| Application number: 2025/62/90526/E |  |
| What is the application for?:       | Demolition of single storey extensions and erection of single and two storey ext |
| Address of the site or building:    | 5, Cumberworth Road, Skelmanthorpe, Huddersfield, HD8 9AB                        |

| Type of comment: An objection  |    |

title Site plan as proposed & location plan
number 24107D-02-P03
scale 1:200 & 1:1250
size A1

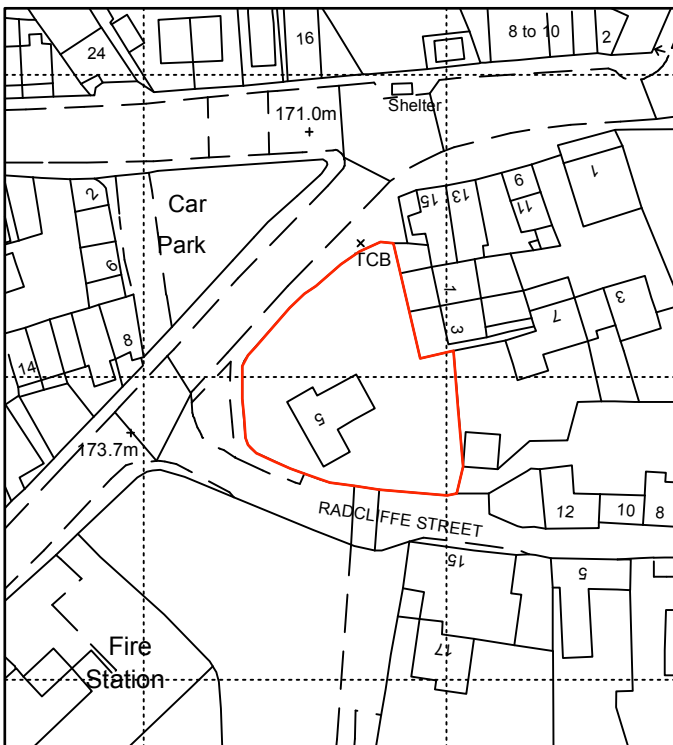
| Upper Dearne Valley Environmental Trust (UDVET) would like to make the STRONGEST OBJECTION to the landscaping proposals within this application in that they assume the removal of TPOs. We welcome the reinstatement of the hedge after this and an extensive amount of other vegetation was recently ripped up from the site. We have also objected to the removal of the TPOs on this site contained in separate Application 2025/TNA/90609/E of which the Tree Officers are aware. |    |
